Response to Planning Application

From: Arun District Council Greenspace

Application ref: P/38/20/DOC

Description: Approval of details reserved by condition imposed under ref P/70/19/RES relating to Condition Nos 4 - paved & gated access, 6 - charging of electric vehicles and 9 - new signage to encourage responsible dog ownership.

Sign image graphics shown for indication only, or similar approved.

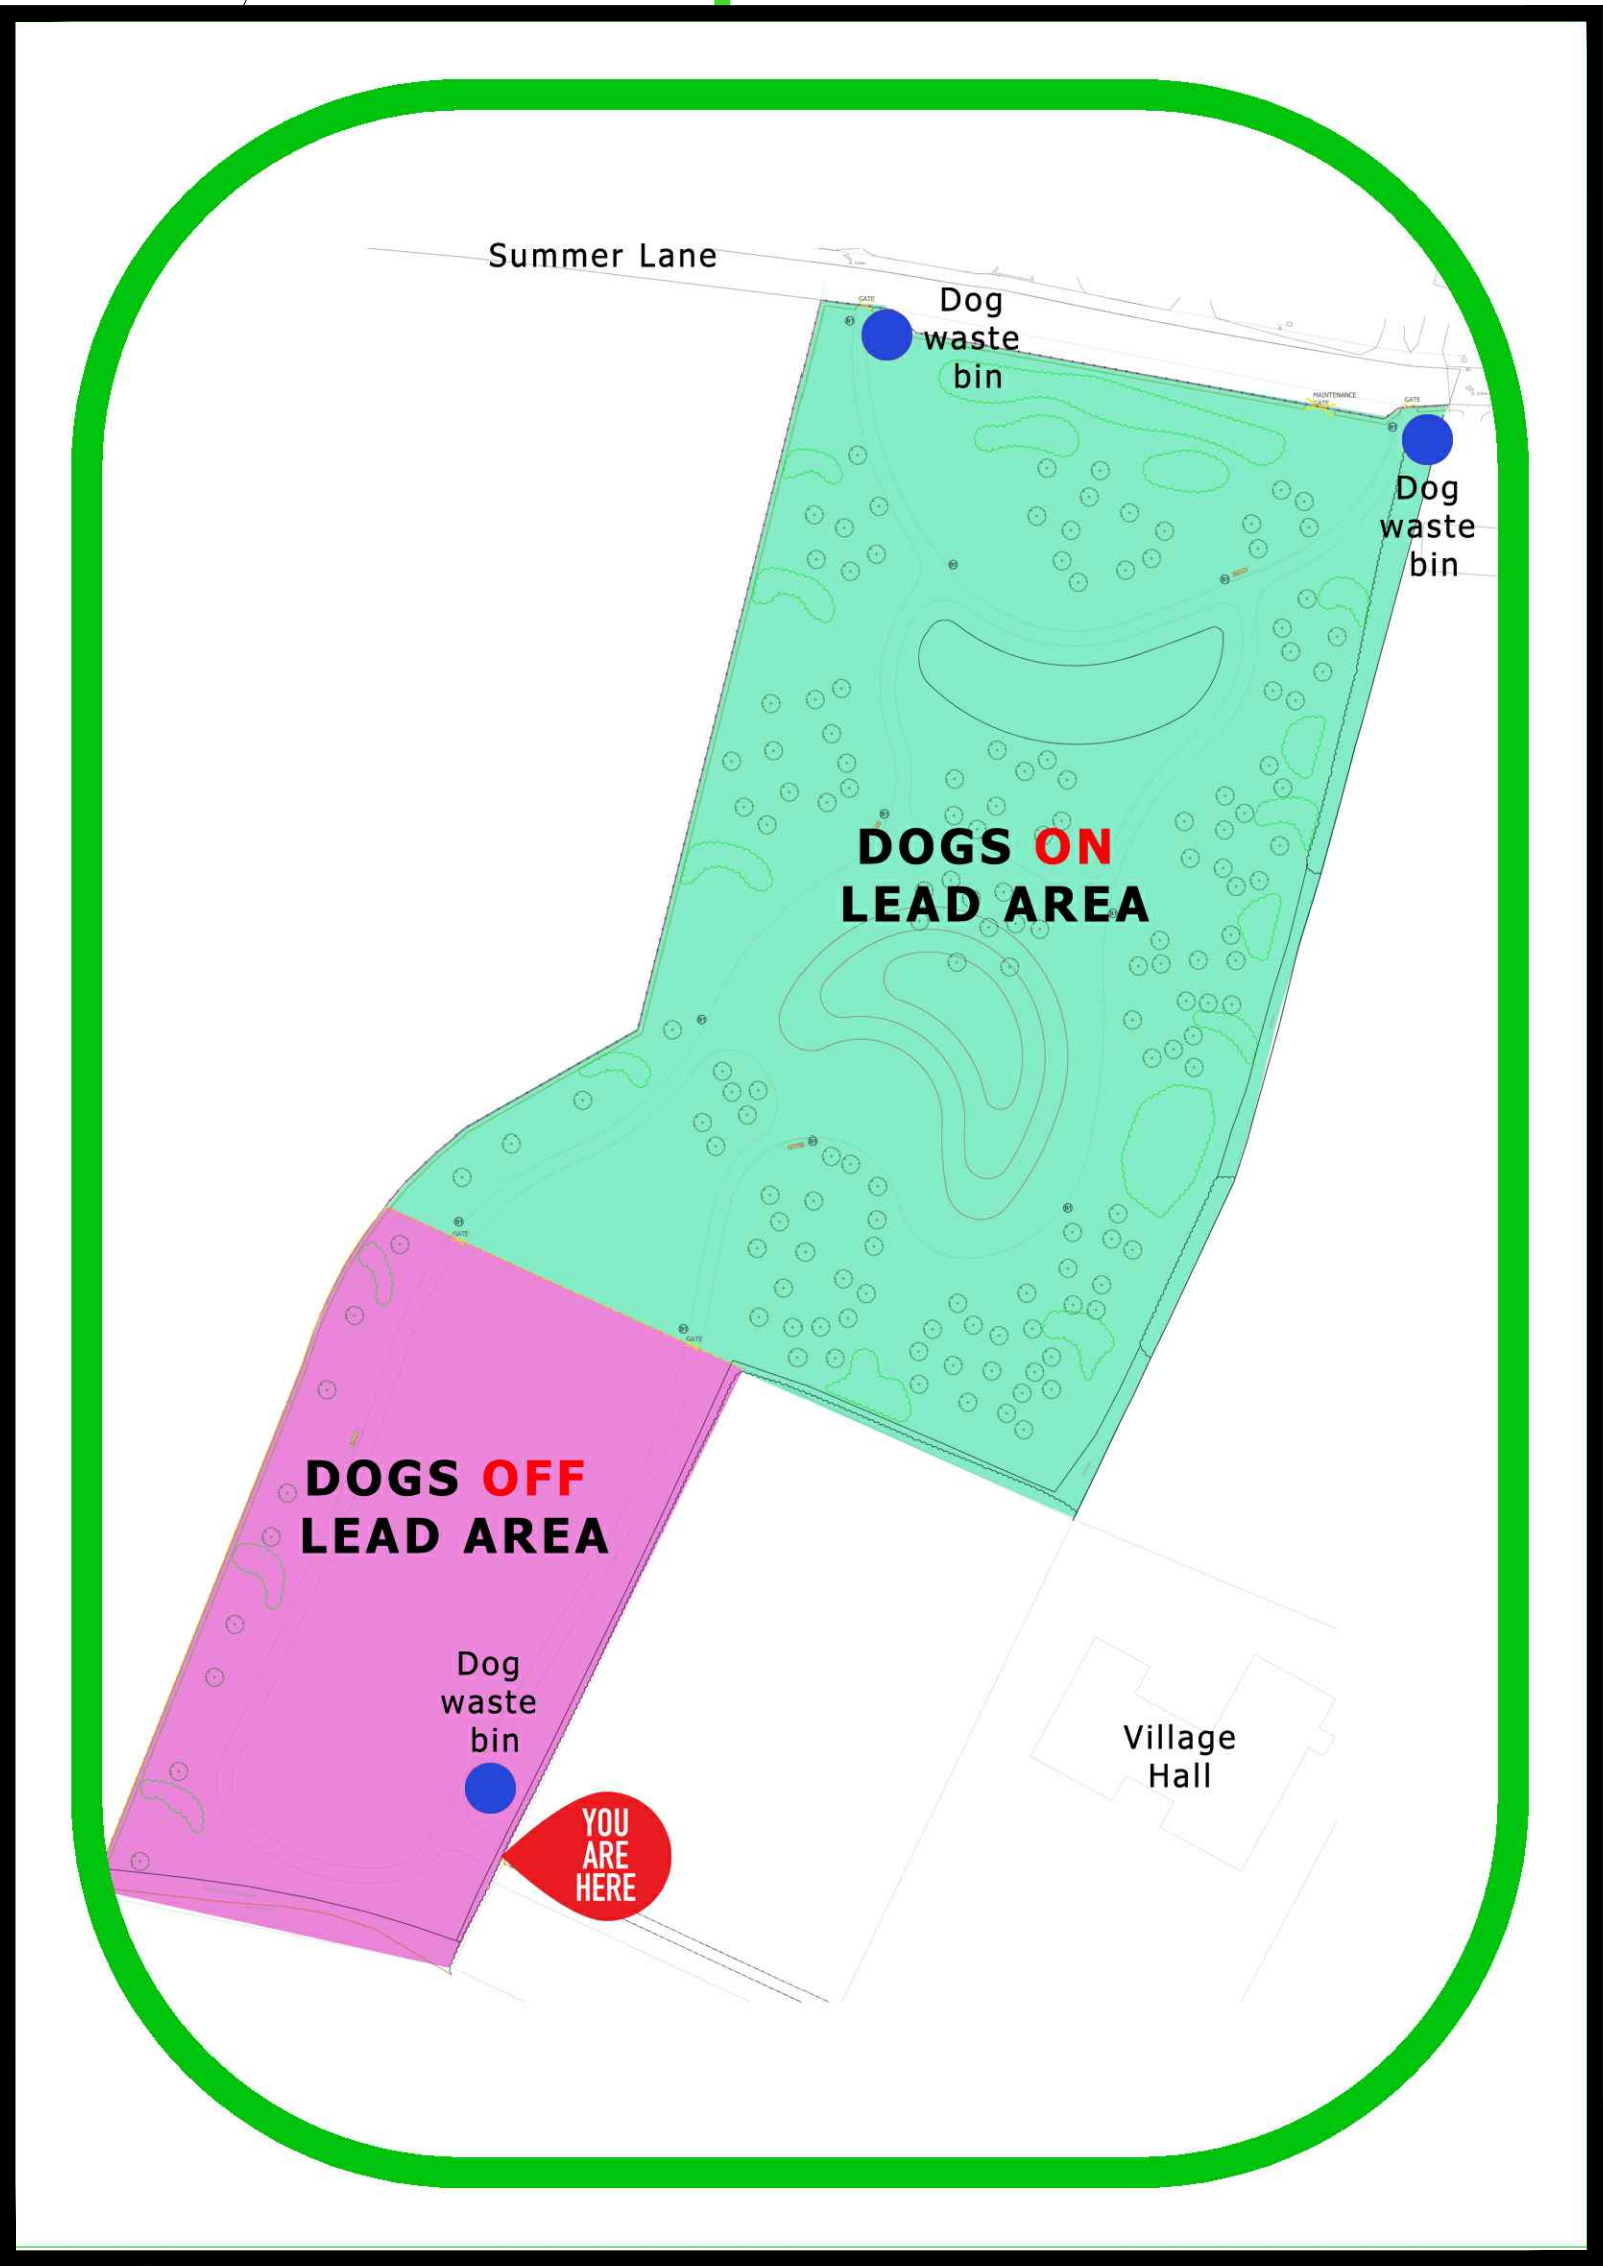
Following submission of POS Dog Walking strategy Dwg no M323-355 Rev P1 I can confirm that this does contain suitable information to inform the public of the requirements in this area, therefore I would **recommend the discharge of Condition 9** on this application imposed under P/70/19/RES
